TELECOMMUNICATIONS REPORT

DESCRIPTION/ ADDRESS	- Prior notification for 12m monopole designed to reflect a telegraph pole and associated equipment cabinets. Junction of Westergate Street and Meadow Way, Westergate, Aldingbourne.
-------------------------	--

AL/58/07/TEL

Prior notification for 12m monopole
designed to reflect a telgraph pole and
associated equipment cabinets

EAST ELEVATION
SCALE 1:100

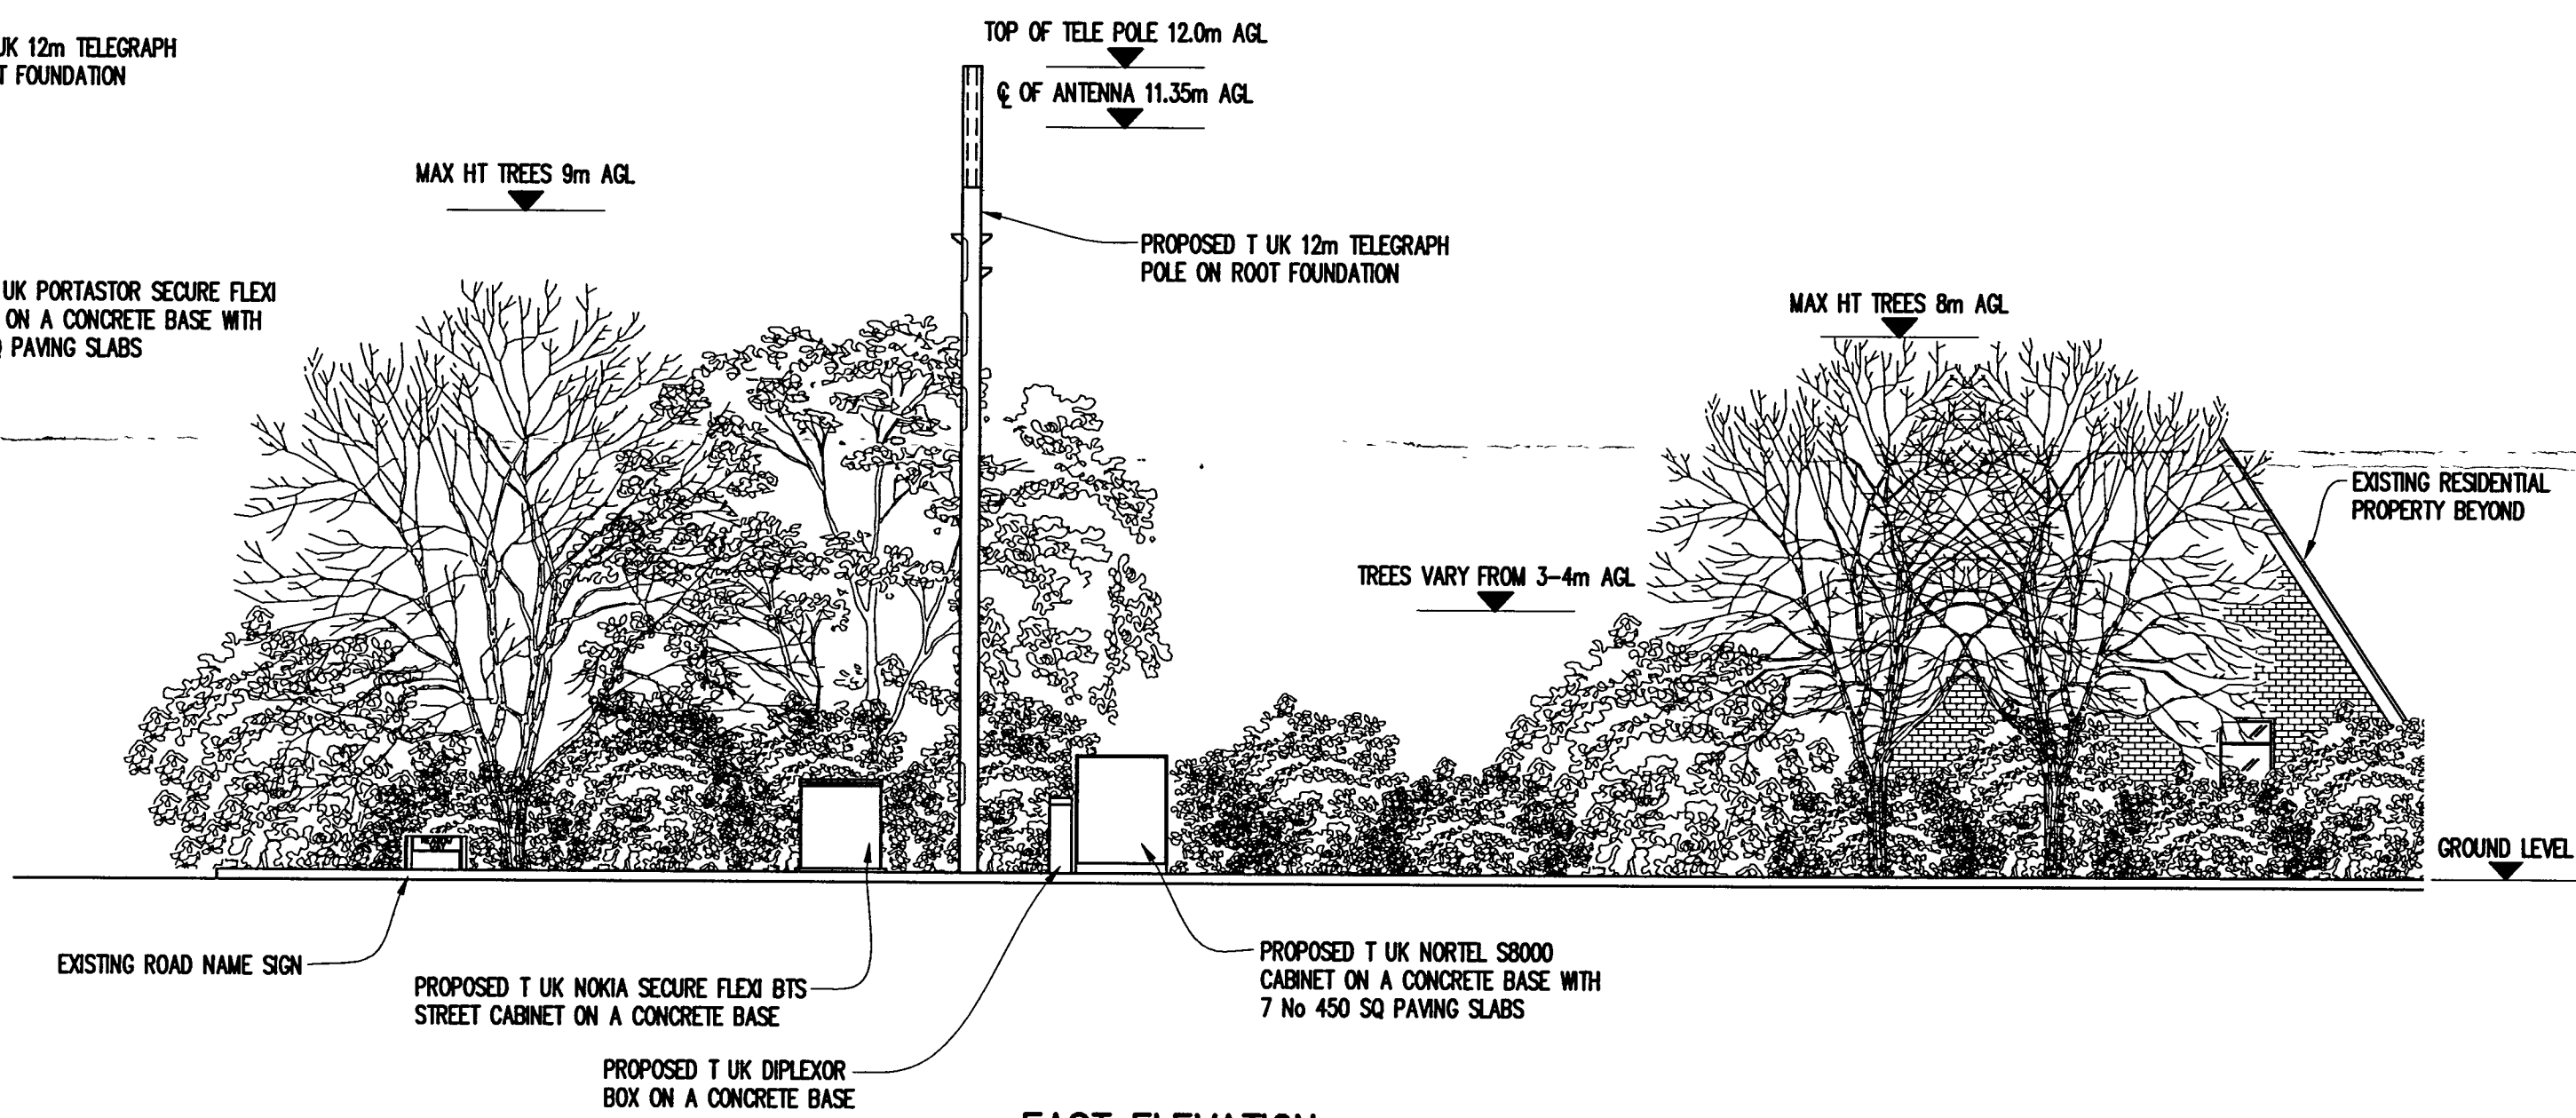
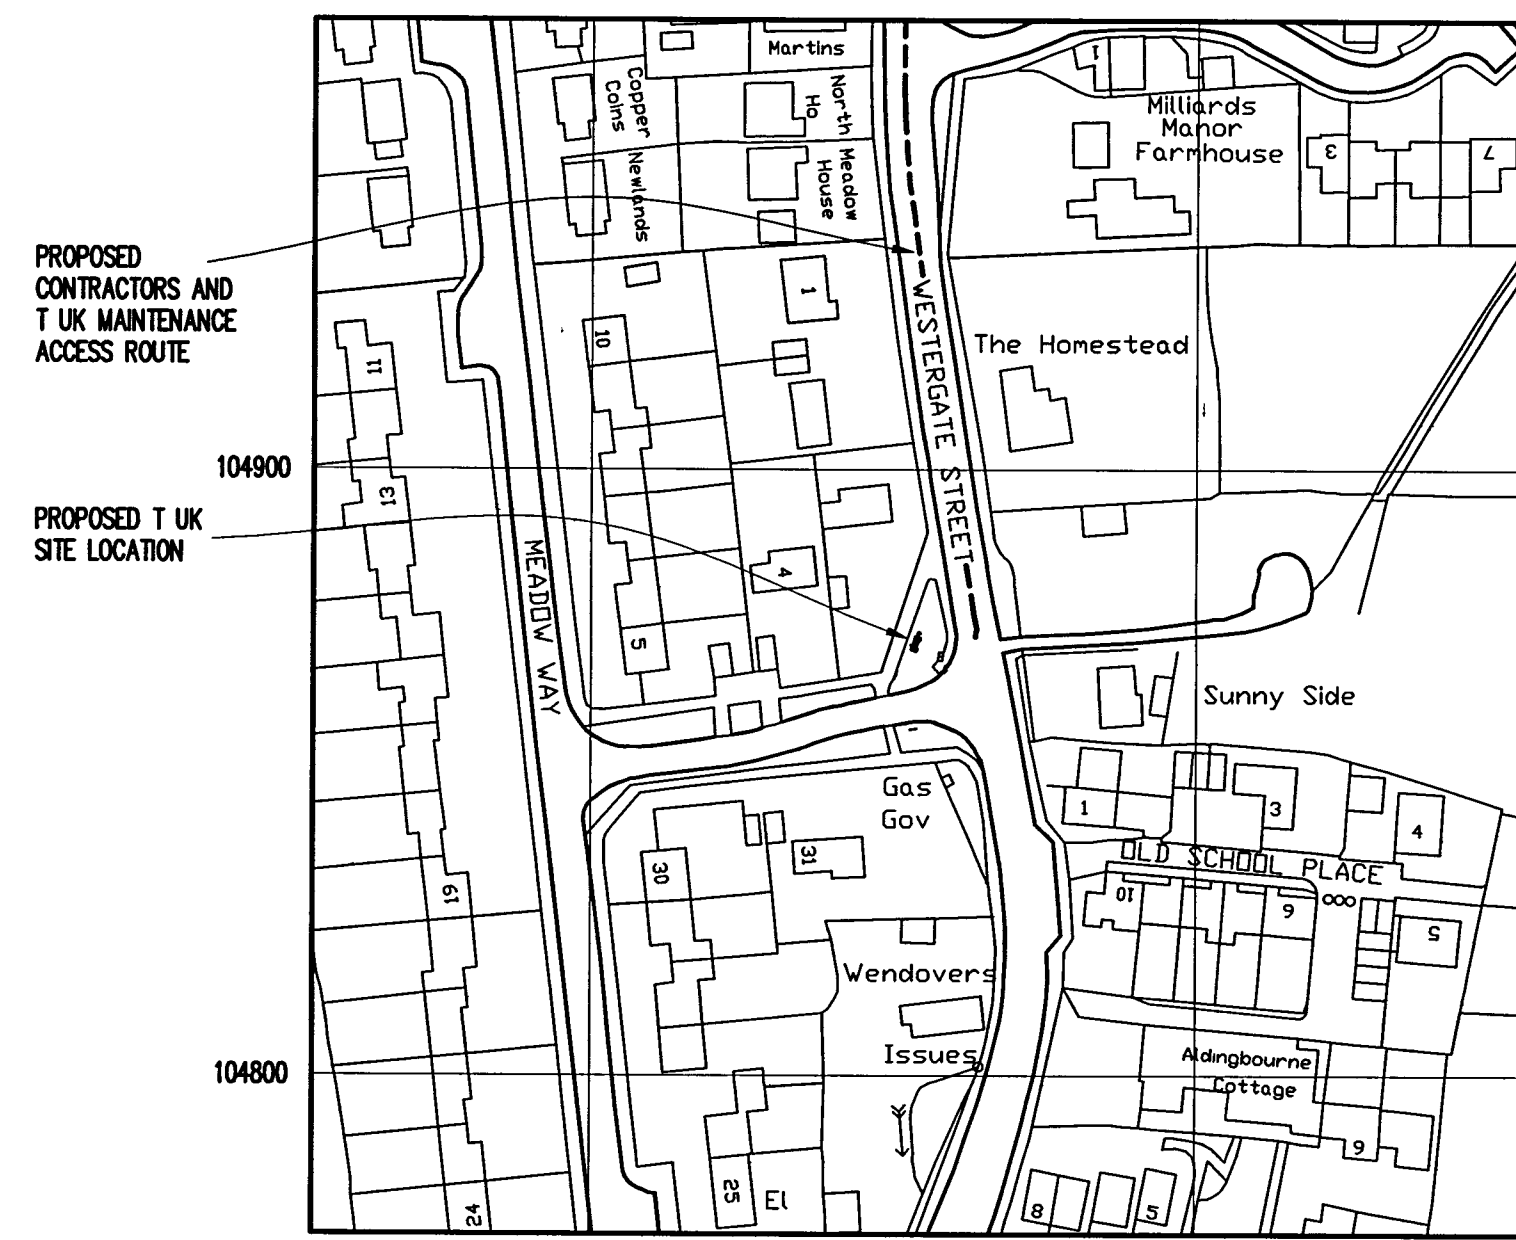
The proposal includes a 12m replica telegraph pole type mast and associated equipment cabinets. The proposed mast and cabinets would be sited on a grass verge, on the corner of Westergate Street and Meadow Way. Westergate Street is located to the east of the site; Meadow Way would be located to the south side and a 1m wide tarmac pavement runs to the rear north west side of the application site.

It is considered that the proposed equipment would appear prominent and obtrusive in the street scene. Further, it is considered that its position and the associated equipment cabinets would separate the structure from assimilating into the existing vertical lamp post pattern. This corner site is easily seen when approaching from Lidsey to the south or Eastergate to the north and there are no lamp posts on this side of the road on the bend. The equipment would therefore be viewed as an isolated structure without the benefit of any screening to soften its appearance or act as a backdrop.

It is therefore recommended that an objection is raised to the siting and design of the proposed equipment on the grounds that the Local Planning Authority is not satisfied that a sufficient, rigorous or thorough investigation of alternative, less sensitive sites, a greater distance from the nearby school has been fully investigated and the mast proposed would be a prominent and obtrusive feature in the street scene to the detriment of the visual amenities of the surrounding area.

- 1 The proposed siting of the equipment would result in a prominent and obtrusive feature in the street scene which would adversely affect the visual amenities of the locality in conflict with policies GEN7 and DEV41 of Arun District Local Plan and policies DEV1 and NE23 of West Sussex Structure Plan.
- 2 Alternative sites (including those which are a greater distance away from schools) have not been fully explored, and it has not been satisfactorily demonstrated that this is the most appropriate location for the installation. The proposal therefore conflicts with policies NE23 of West Sussex Structure Plan and DEV41 of Arun District Local Plan.
